Your ref: Tilbuster 2 Solar Farm (SSD-69799460)
Our ref: 12636761

Tilbuster 2 Solar Farm Response to Submissions Report – Request for Additional Information

GHD Pty Ltd (GHD) has been engaged by Quintas Energy (Quintas) on behalf of EP Sunspot 5 Pty Ltd (the proponent) to prepare this response to a request for information (RFI) (dated 3 March 2026) relating to the Response to Submissions Report prepared for the proposed Tilbuster 2 Solar Farm (the proposal).

Figure 2.5 New England Highway traffic volume data calculated to 2024 (weekdays)

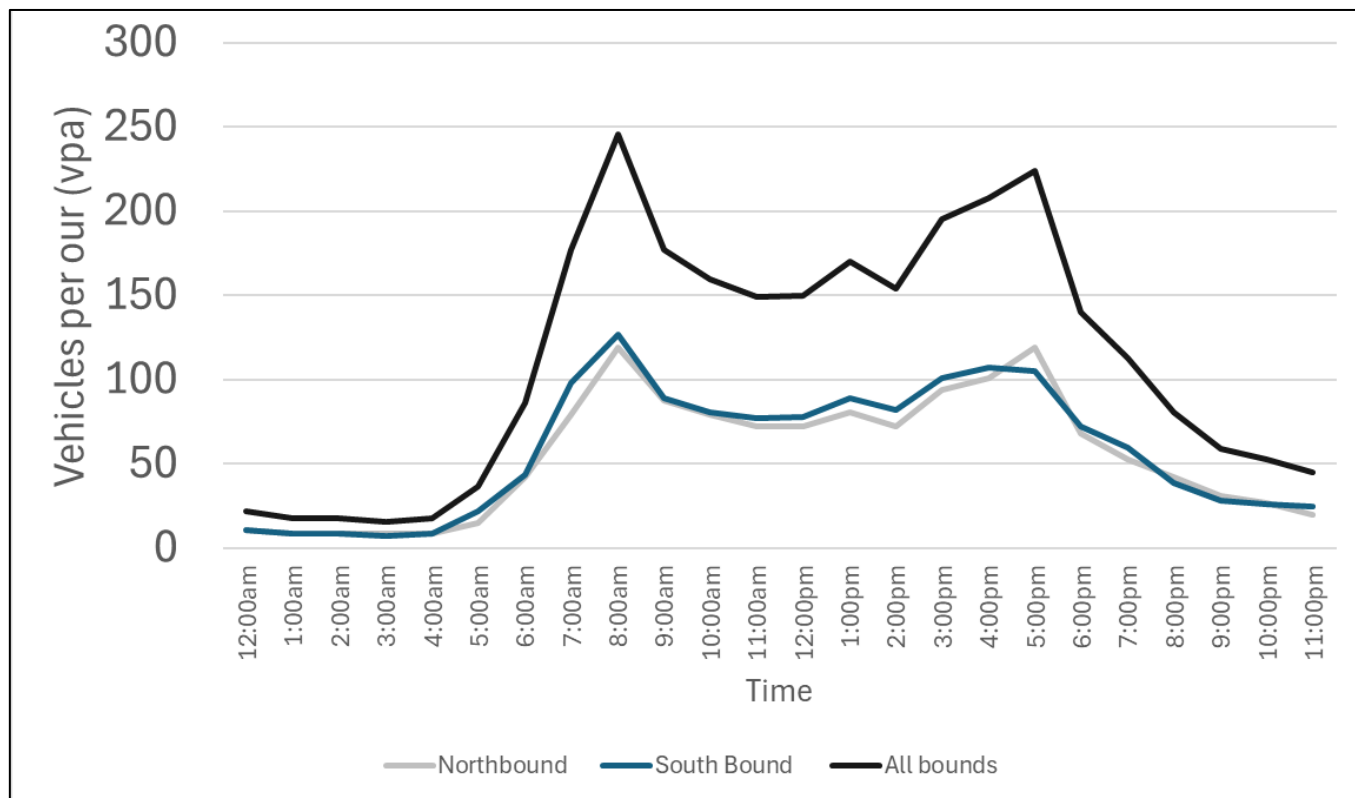
Figure 2.5 uses inconsistent units. Please amend in the updated TIA.	Figure 2.5 has been updated.
OSOM swept paths are to be removed in the revised TIA if OSOM are not to be used.	Appendix B and C have been deleted.
Gate to be removed Stage 1 access road.	This is not directly relevant to proposal but will be actioned by the proponent.
Dimensions of the transformers and their associated vehicles.	The proponent has advised that no transformers are required for the proposal.
